PLANNING SECTION

Our Ref: RA/S51941

Your Ref: ABP-305436-19

Development Description: Whether or not the subdivision of the unit into two separate units is or is not development, or is or is not exempted development? Whether the use of part of the existing building for use for storage of materials is or is not development or is or is not exempted development? Whether the use of the yard Area 3 for the storage of materials is or is not exempted development?

Floor Plan

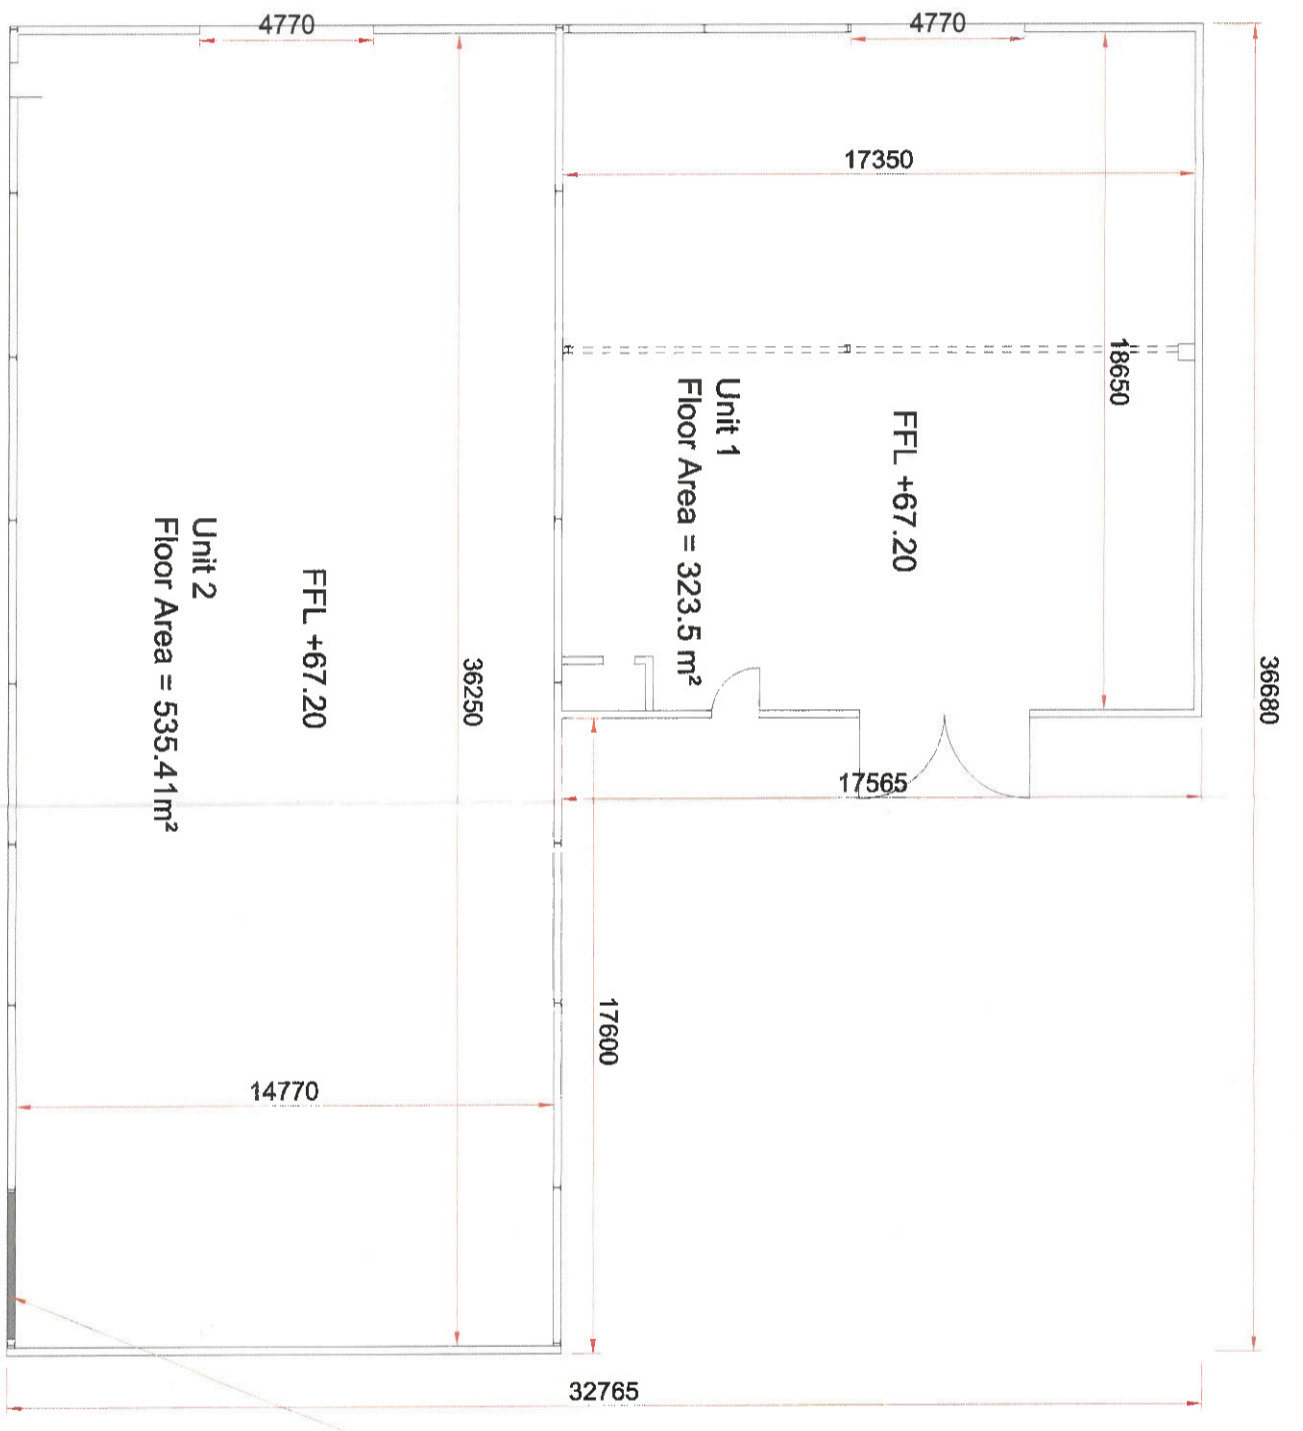
The subdivision of the subject unit into two separate units is considered to materially affect the external appearance of the structure so as to '*render the appearance inconsistent with the character of the structure/ neighbouring structures.*'
